**MEMORANDUM**  
**City Council Agenda Item**

**SUBJECT:** Material substitution for apron at Munjoy Heights townhouse development (79 Walnut Street)

The applicant, Jonathan Culley of Redfern Munjoy LLC, received Planning Board approval to develop the townhomes known as “Munjoy Heights” on December 17, 2013 and the project is now in the final stages of construction. The applicant requested a brick apron where the pedestrian/vehicle access links the 29 new townhouses known as “Munjoy Heights” to Walnut Street, as shown in the attached plan. The City’s Sidewalk Replacement Materials map specifies a brick sidewalk with asphalt apron at this location and the City Council is requested to approve this substitution of brick for the 205 sq ft asphalt apron area.

BRICK DRIVEWAY APRON WITH BITUMINOUS BASE DETAIL
NOT TO SCALE

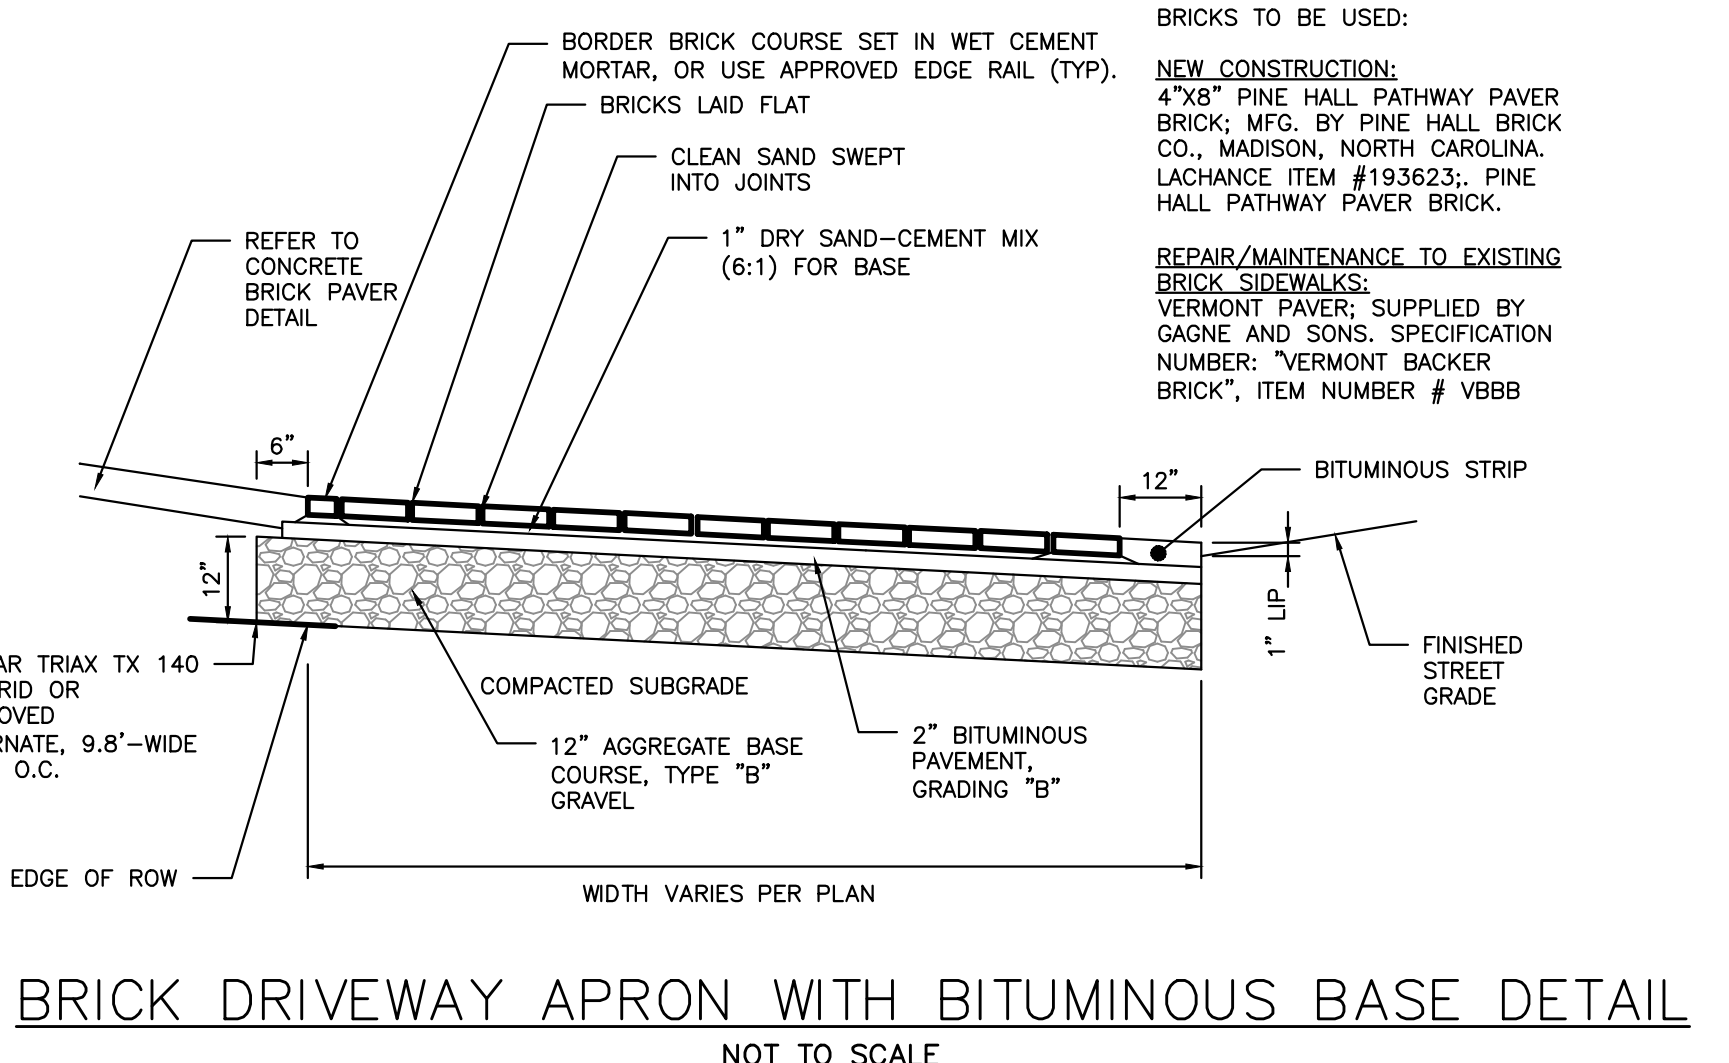
The project includes a pedestrian/vehicle area between the townhouses that is surfaced with brick and other non-asphalt materials to create an attractive character to the area, and the applicant would like the small section of abutting apron to be of a similar material rather than the asphalt that is required by strict compliance with the Sidewalk Materials policy. The replacement and maintenance easement that the applicant has agreed is similar to easements that have been agreed for similar substitutions elsewhere.

The City Council is recommended to approve the material substitution (brick to be substituted for asphalt in apron area) as shown on the attached plan, and the associated attached maintenance and replacement easement.

DRAWING NO.
C-10

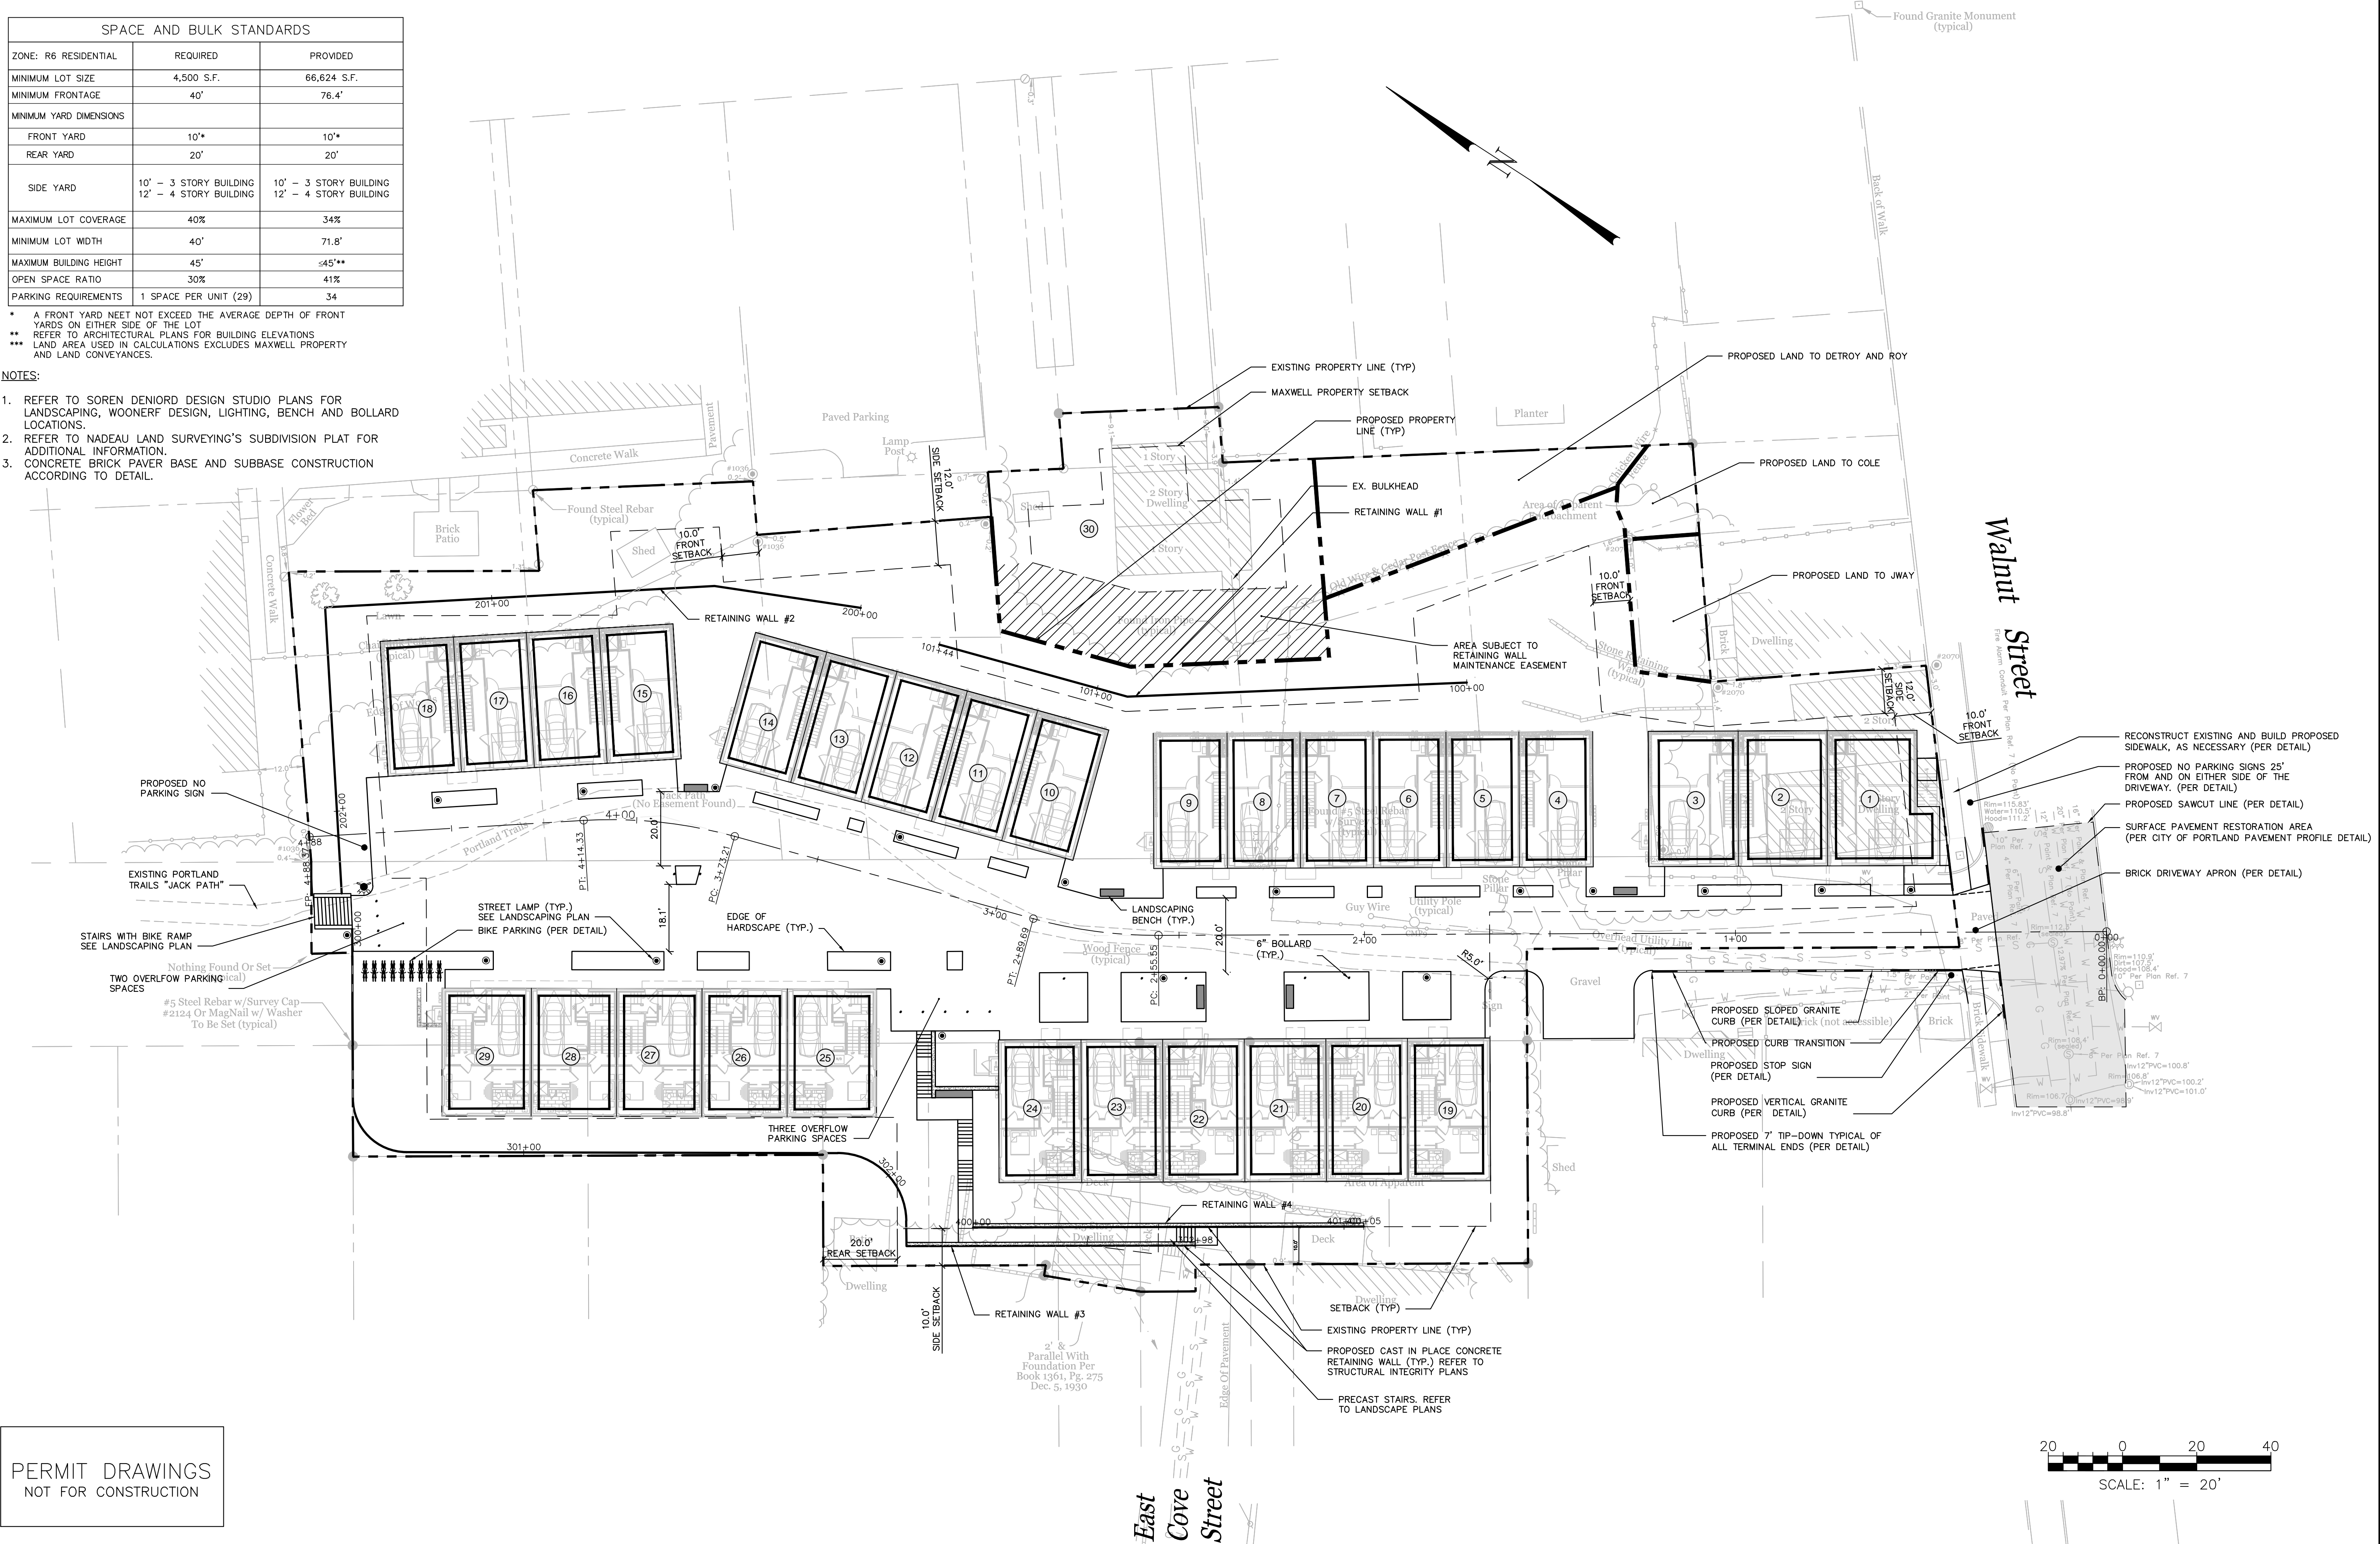
Planning Division staff note that the brick apron was shown on the plans approved by the Planning Board, accompanied by a note stating “subject to City Council approval”. Staff were concerned that the apron would be subject to vehicle use and is near well used pedestrian routes (a route to school and Jack Path) and therefore it was recommended that a maintenance and replacement easement was appropriate to ensure the brick is maintained. The Department of Public Services supports the substitution subject to the easement being in effect and the Legal Department has confirmed that this does not require TS&E committee review.
